# Rezoning Transportation Analysis

Petition Number: 2020-119

## Revision Log:

Date	Description
09-11-2020	First Review (KP)

SHEET NUMBER  
**RZ-2**

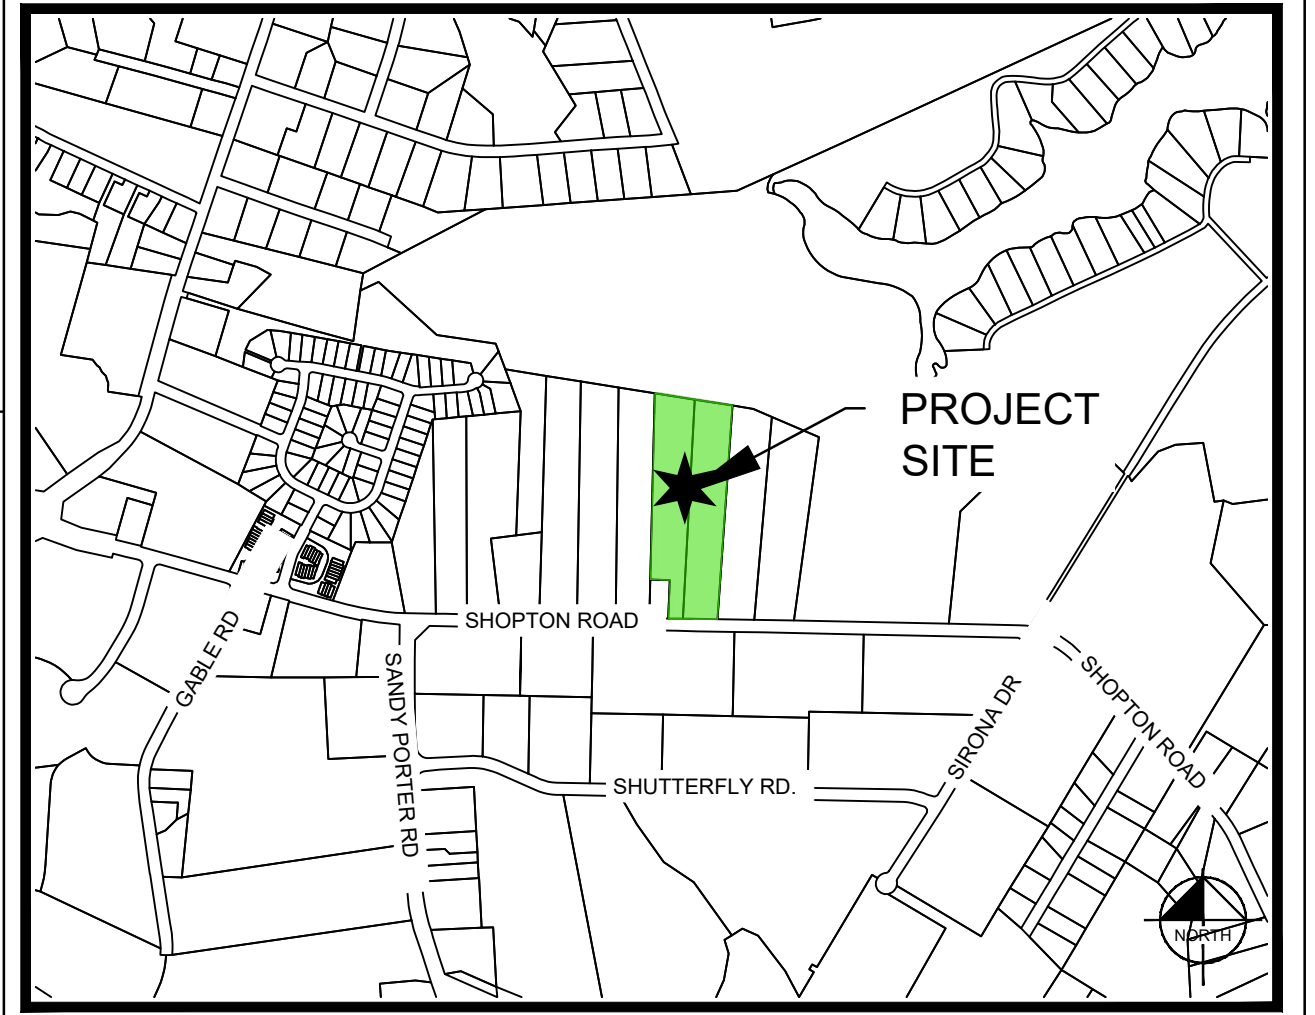
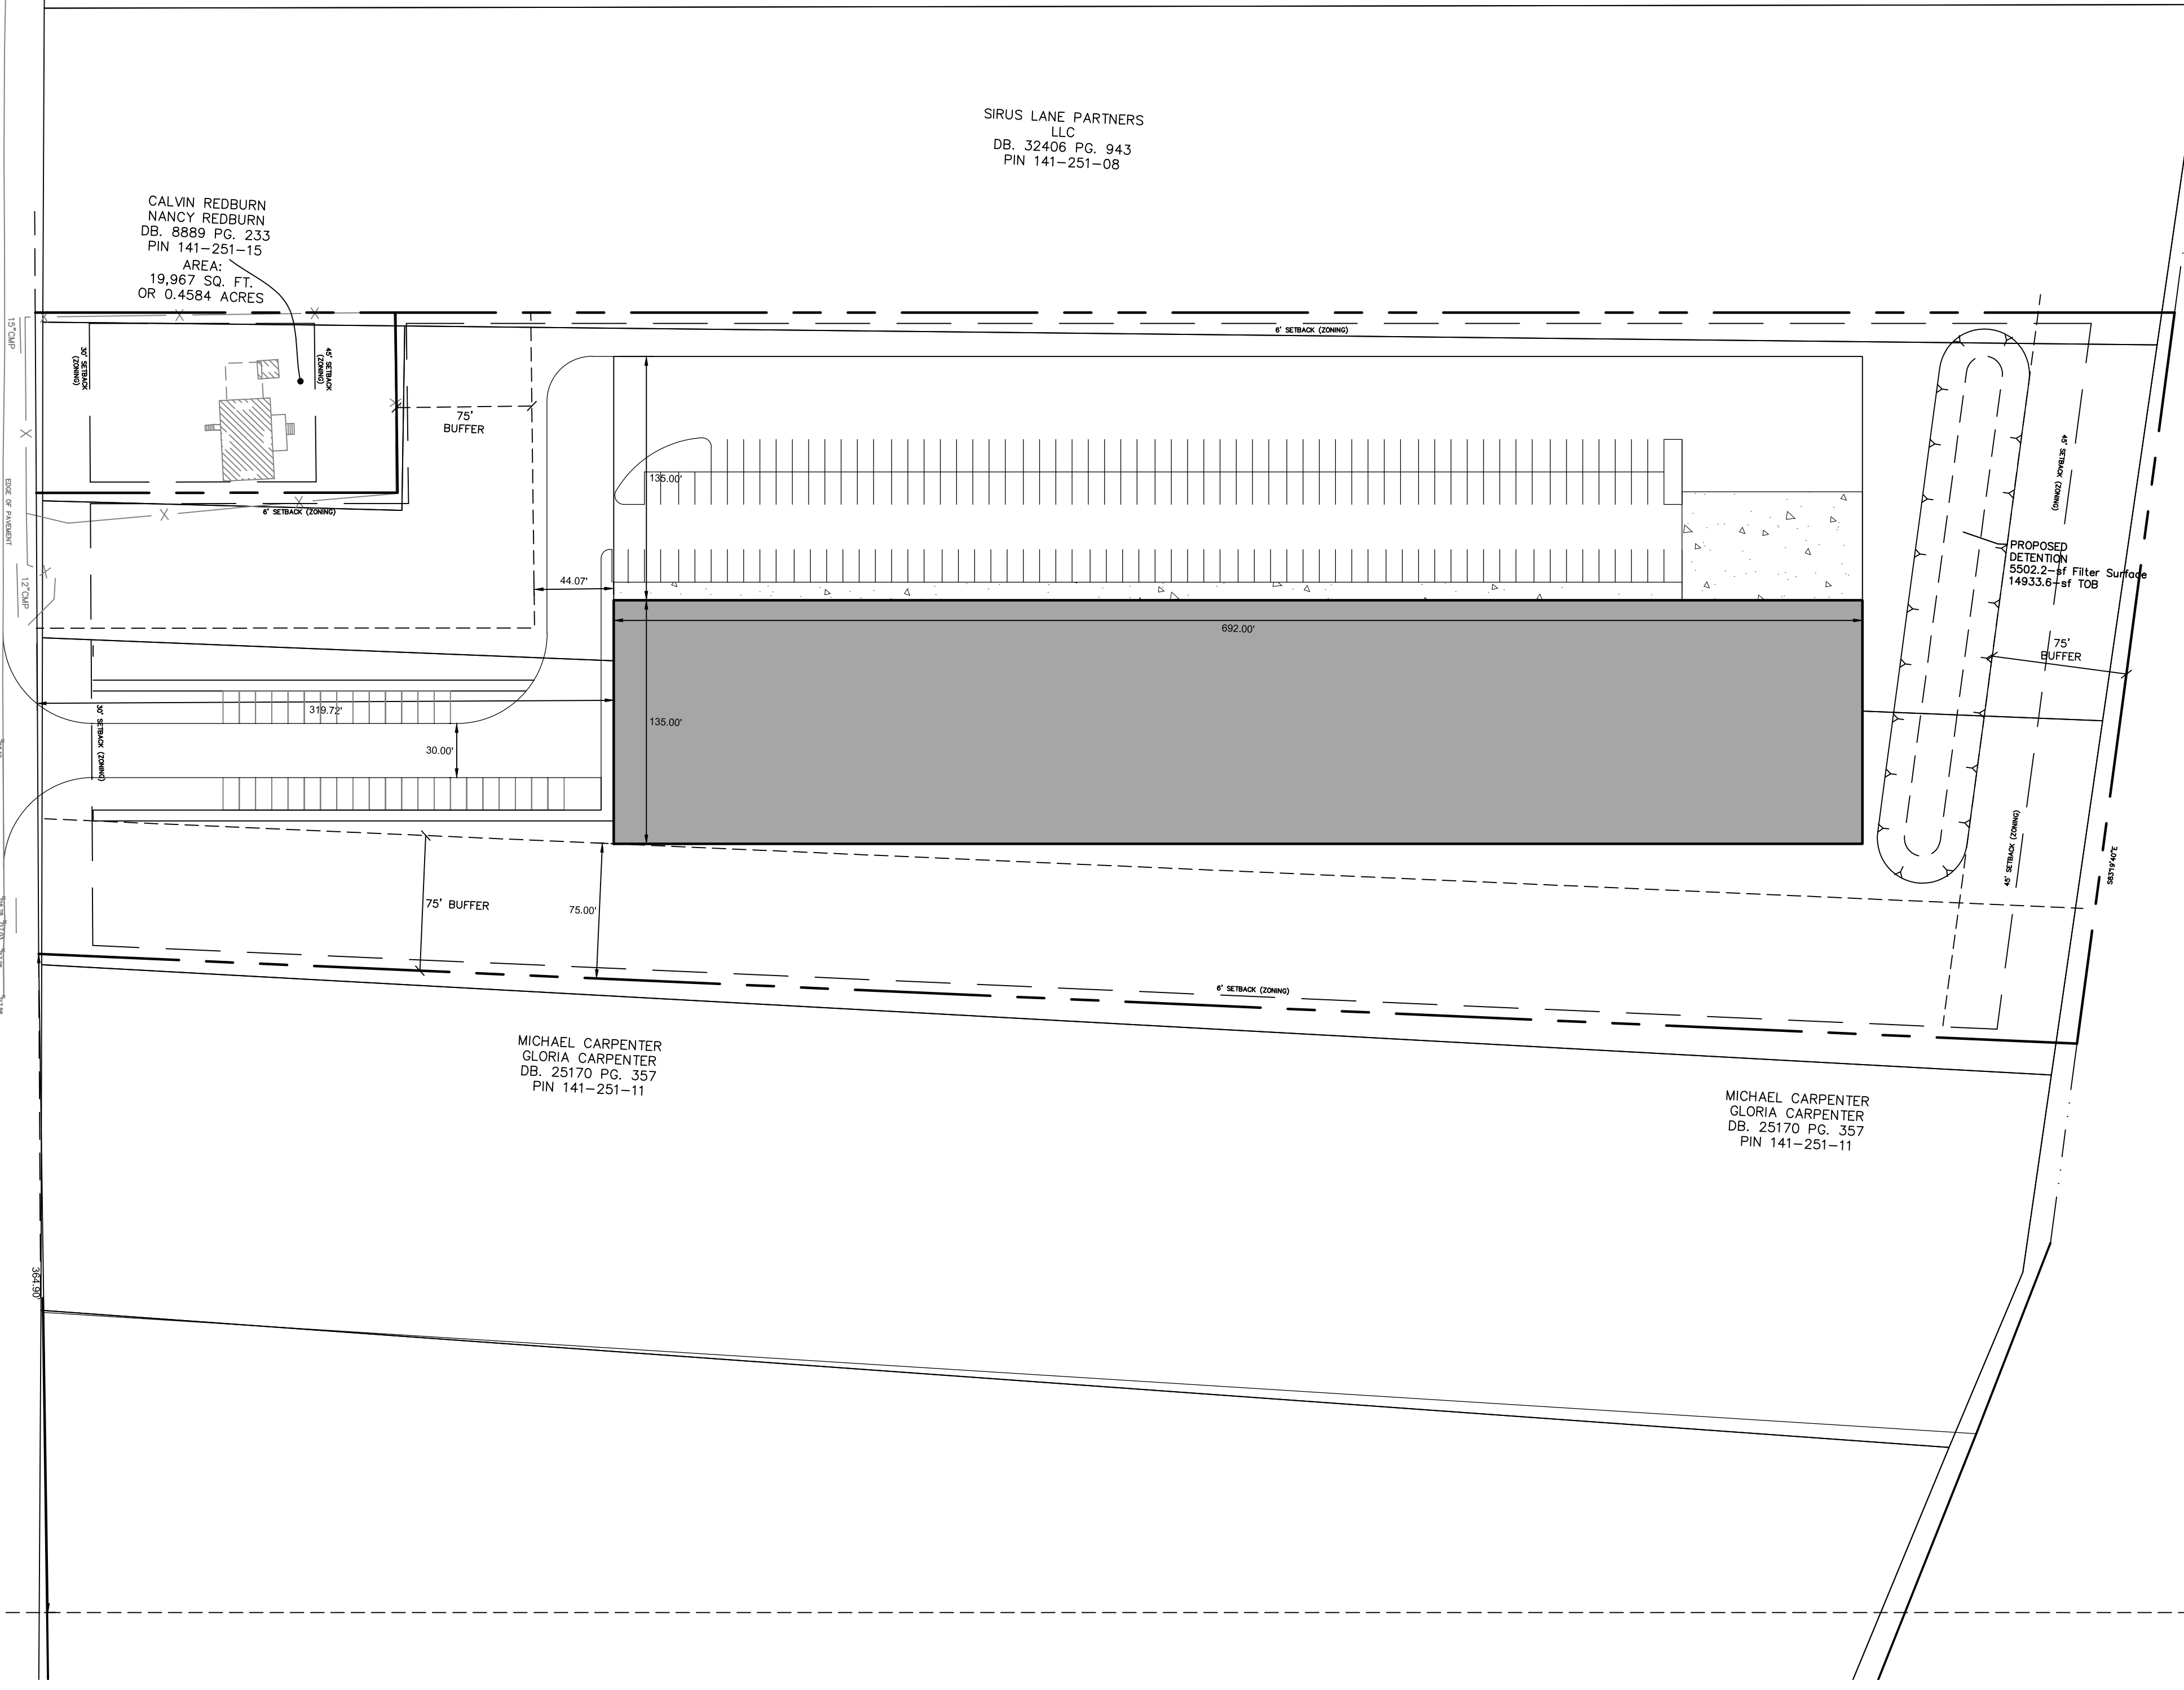
1. **Curb Line** - Shopton Road: The future location of curb and gutter is located 27-feet from the centerline to back of curb.

The site plan needs the curb and gutter labeled and dimensioned from the centerline for each road.

3. Commit to dedicate 43-feet of right-of-way from the Shopton Road centerline, labeled and dimensioned from the road centerline.
4. Revise the site plan and conditional note(s) to commit to construct an 8-foot planting strip, and 6-foot sidewalk on Shopton Road, as per City ordinance, labeled and dimensioned from the back of curb and gutter and road centerline.

5. Revise the site plan and conditional note(s) to commit to construct a 5-foot bicycle lane with a 3-foot buffer along Shopton Road, labeled and dimensioned from the road centerline.

6. Revise the site plan and conditional note(s) to commit to re-striping the existing striped median to encumber an eastbound left turn lane with 150-feet of storage and appropriate bay taper.

8. Revise the site plan to add a note specifying dedication and fee simple conveyance of all rights of way to NCDOT before the site's first building certificate of occupancy is issued. CDOT requests right-of-way set at 2' behind back of sidewalk, where feasible.

9. Revise the site plan to add a note specifying all transportation improvements will be approved and constructed before the site's first building certificate of occupancy is issued. The petitioner may phase transportation improvements if said improvements and phasing are explicitly described in site plan notes.
